**SSD 10294 and SSD 8874 MOD 1 Sydney Metro Victoria Cross OSD
Response to Submissions**

Thank you for your correspondence via Major Project portal (ref: PAE-3088 and 3082) on 4 May 2020, requesting Transport for NSW (TfNSW) to review the Response to Submissions (RtS) prepared by the applicant. Legislation came into effect on the 1 December 2019 that brings the former Roads & Maritime Services and Transport for NSW together into one organisation. This response represents the collective views on the RtS that addresses the submissions made by the two agencies during the public exhibition period.

CD20/03981
CD20/03983

Figure 1: Revised loading dock layout

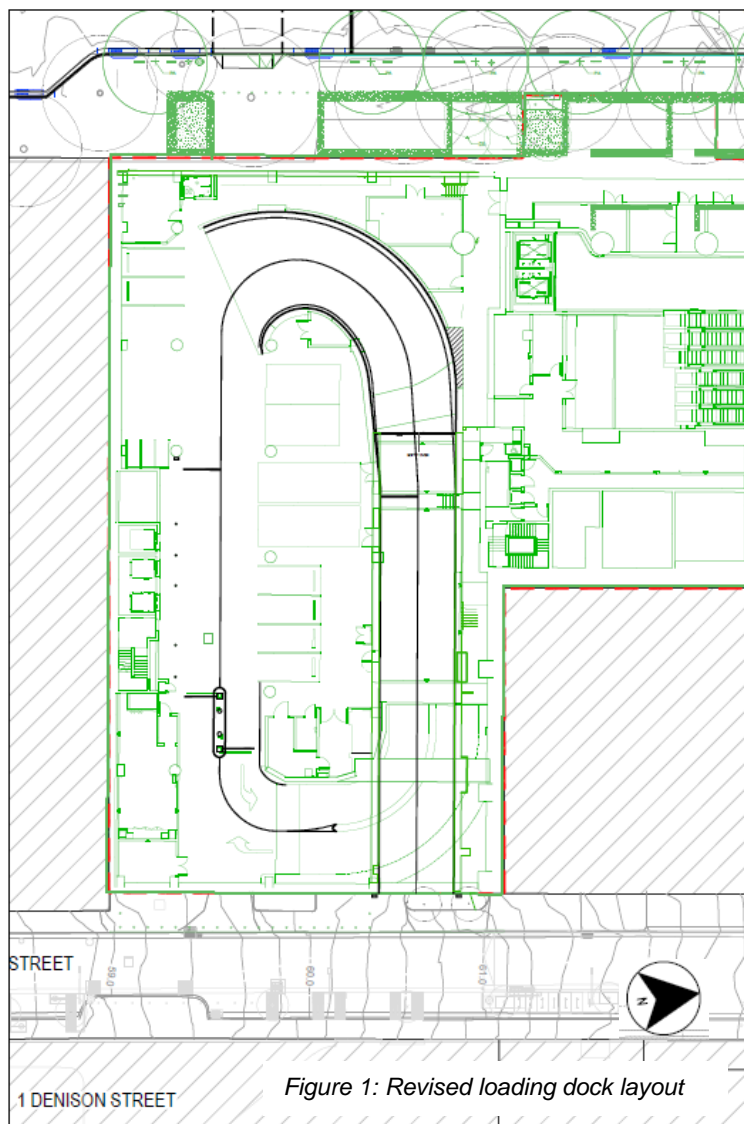
The Response to Submissions document identifies that two of the four courier bays are designated Sydney Metro bays, allocating only six loading bays for the use of the development. The analysis of the development's peak service vehicle and courier vehicle traffic generation discussed in the Traffic Impact Statement, is based on eight loading bays. It is advised that the analysis should be undertaken on only six loading bays. There is also no evidence of quantitative demand assessment being undertaken to identify that the loading bay provision could adequately accommodate the freight and service vehicle demand of the development, including long dwell time vehicles and potentially disrupt the operation of the road network within the CBD due to the circulating freight and service vehicle traffic.

The applicant should be conditioned to prepare a detailed Freight and Servicing Management Plan prior to the issue of construction certificate.
